Application Ref:	3/2025/0739				Ribble Valley Borough Council www.ribblevalley.gov.uk
Date Inspected:	16/10/25	Site Notice:	16/10/25		
Officer:	LW				
DELEGATED ITEM FILE REPORT:					APPROVAL

Development Description:	Proposed replacement dwelling including amendment to facing material from previous approval 3/2022/0449.
Site Address/Location:	Lower Abbott House, Abbott Brow, Mellor, BB2 7HU.

PL.11

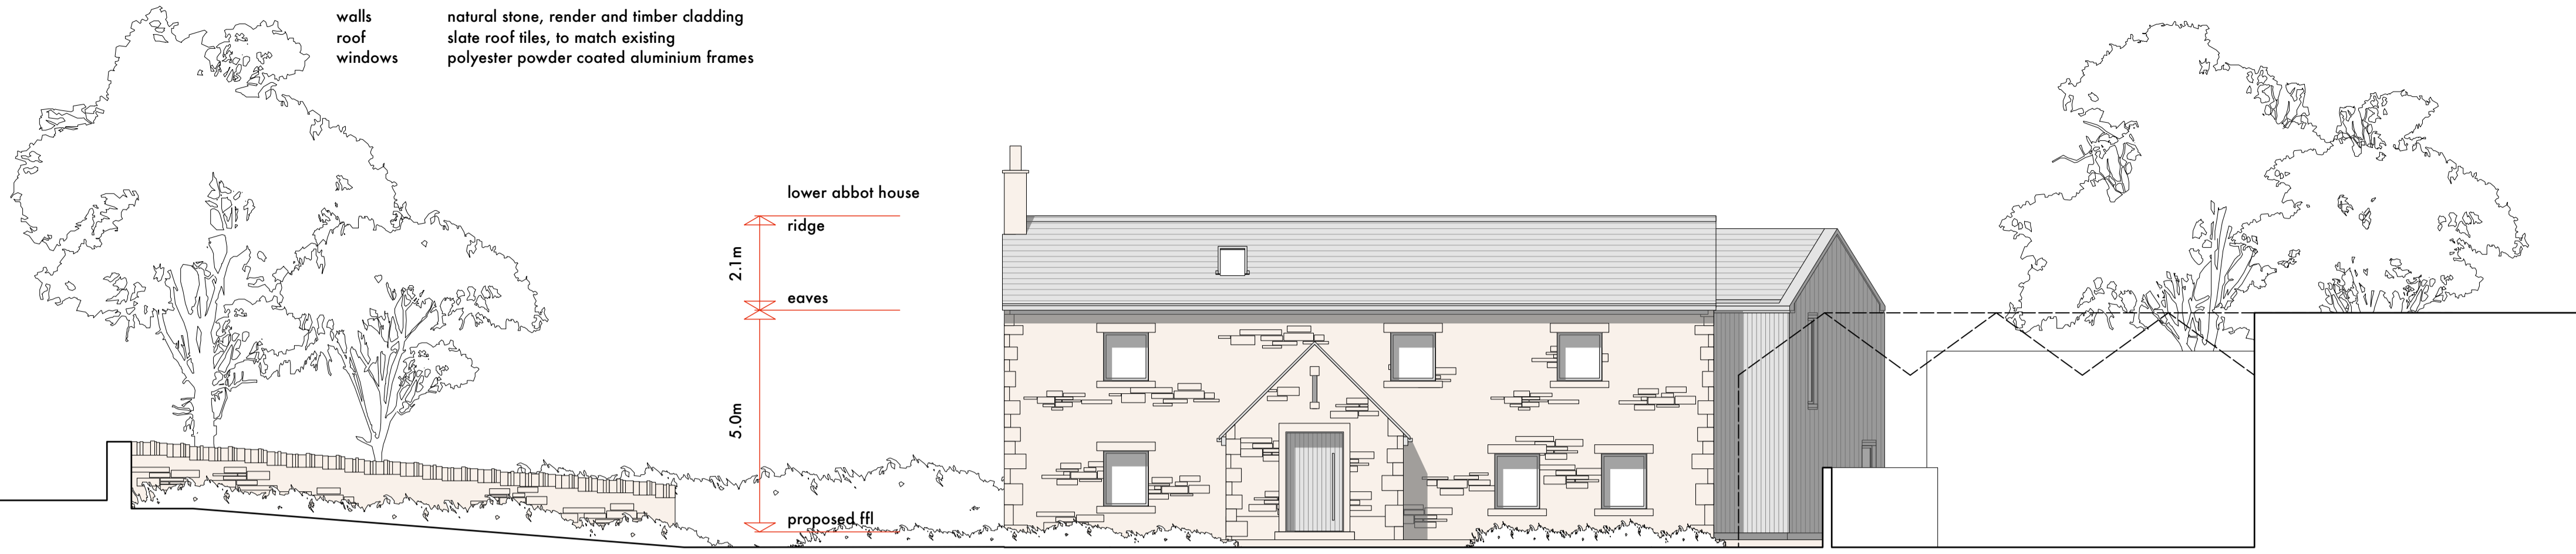
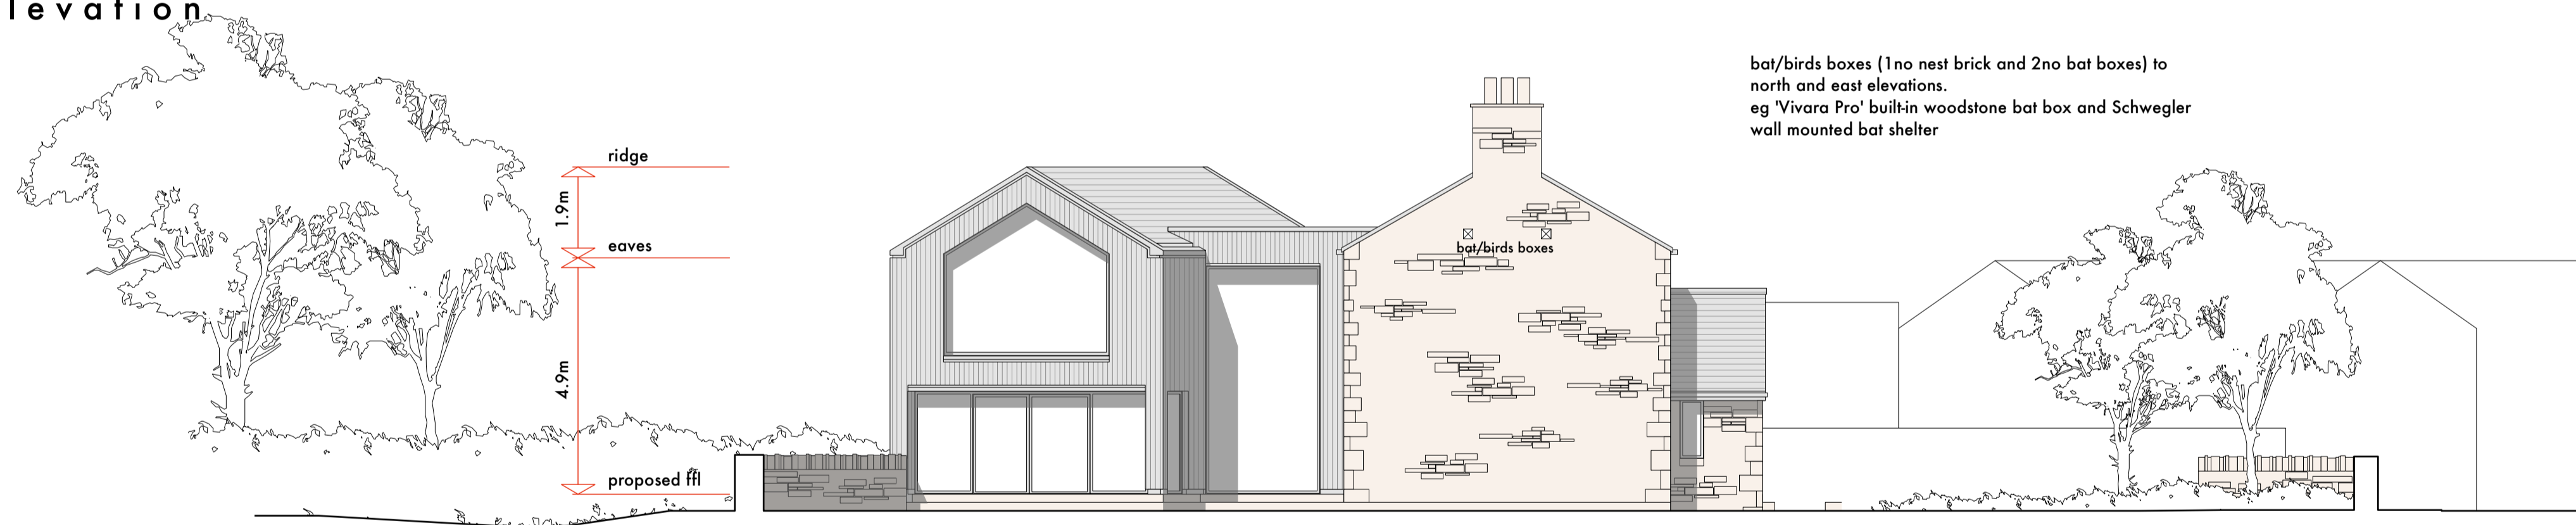
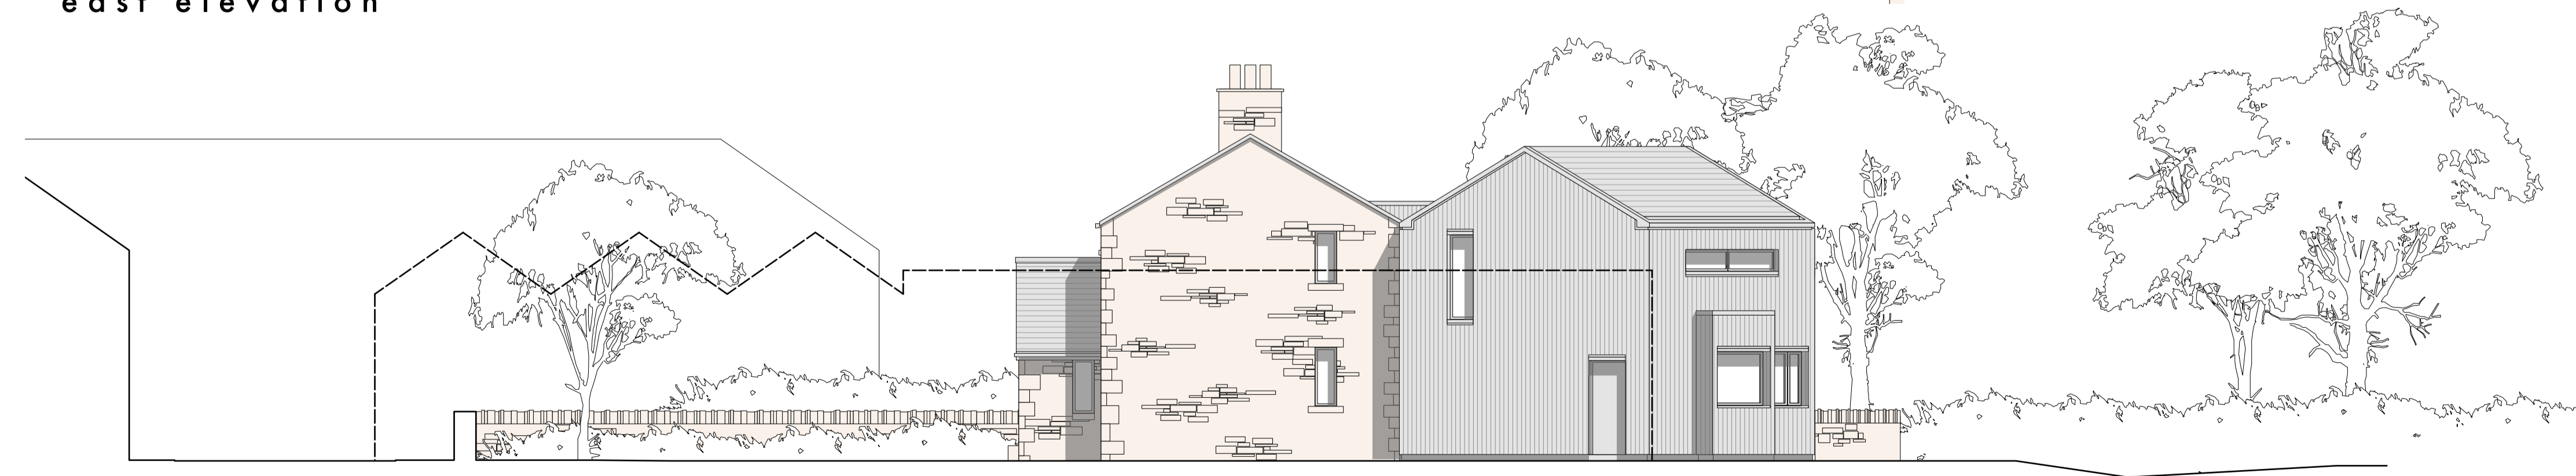
As noted above, the footprint, height and fenestration design of the proposed replacement dwelling would all match the replacement dwelling approved under extant planning permission 3/2022/0449 and non-material amendment 3/2025/0622. The only alteration proposed to the design of the replacement dwelling is the incorporation of timber cladding to the rear of the property instead of the previously approved stone/render.

The revised scheme originally submitted with this application proposed the incorporation of cladding to both the rear of the stone-built element of the dwelling as well as the 'T-shaped' rear wing. However, this was considered to appear incongruous and unsympathetic. Following discussions with the agent, the extent of cladding has been reduced to only include the rear wing, with the rear of the stone-built element now proposed to be rendered, as per the original approval.

Whilst the entire rear wing of the dwellinghouse would still be cladded, this element of the replacement dwelling is already of a modern design in direct contrast with the traditional design incorporated to the stone-built element of the property. The proposed timber cladding would therefore be read in context with the contemporary design of the rear wing, with the glazed link and retention of render to the rear elevation of the stone-built element ensuring that a clear visual separation of the traditional and

contemporary elements would remain. In this respect, the more traditional features of the replacement dwelling would not be lost.
